December 13,2022

Project Name: Proposed Addition Residential Building
29 Russell Avenue
Ottawa, Ontario
EXP Project Number: OTT-22001495-A0
Subject: Geotechnical Review of Latest Grading and Servicing Plan

DESIGNED BY	NW	HORIZ SCALE	1:100	PROJECT #	22030
DRAWN BY	JM	VERT SCALE	N/A	DRAWING #	SGS-1
CHECKED BY	MWD	DATE	MAY 2022	REVISION #	1

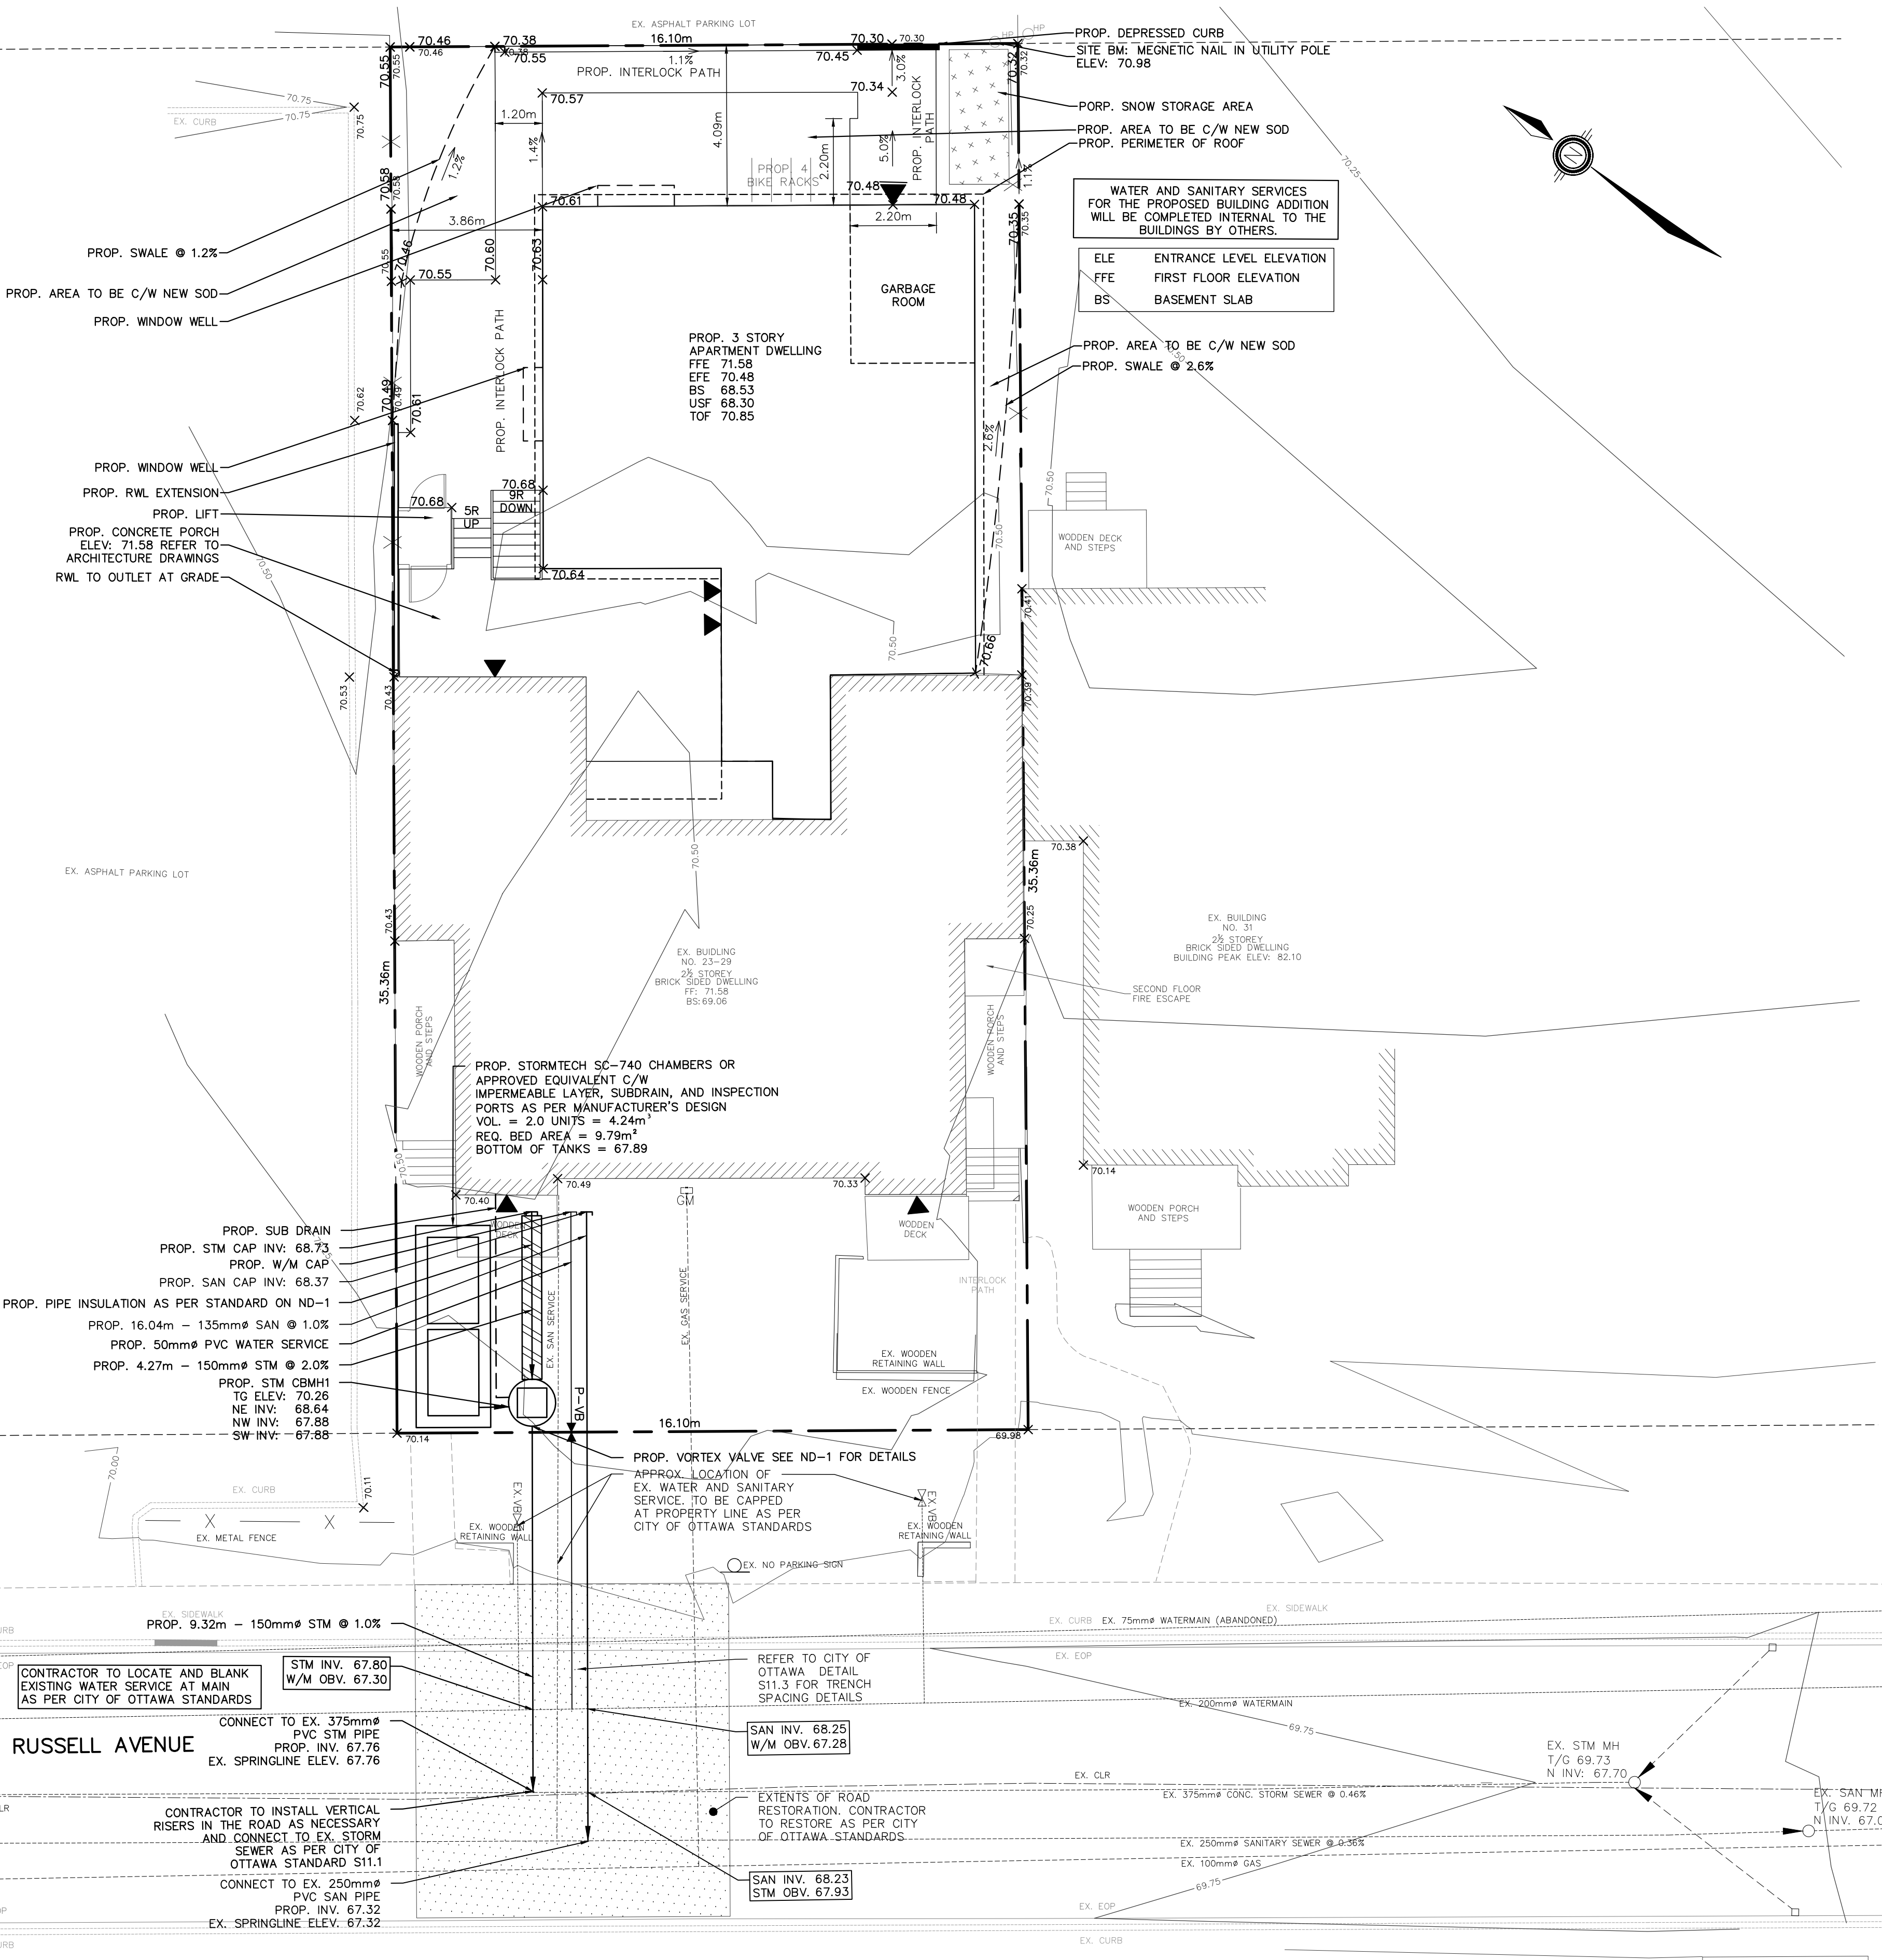
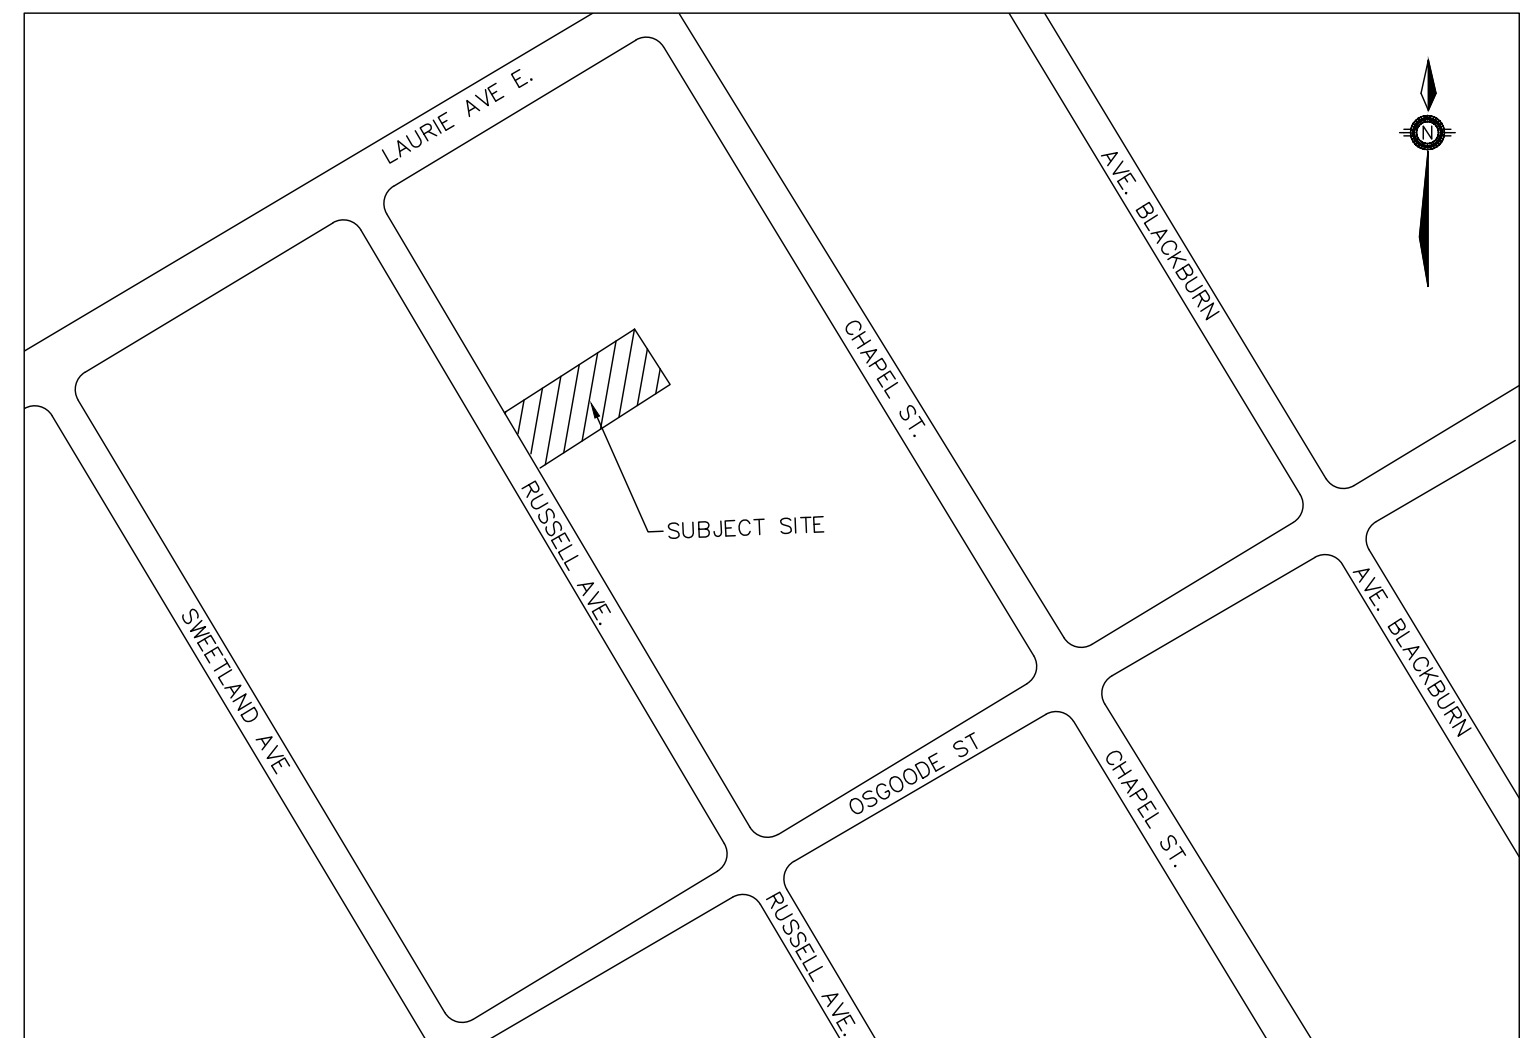
Please submit a letter stating that the latest Grading and Servicing Plan has been reviewed and that it complies with the recommendations and statements of the latest geotechnical investigation.

Based on a review of the latest grading and servicing plan for this project (Drawing No. SGS-1, Project No. 22030) dated May 2022 and prepared by Pearson Engineering, EXP confirms that the grading and servicing plan complies with the recommendations and statements of the latest Geotechnical Investigation report dated May 9,2022.
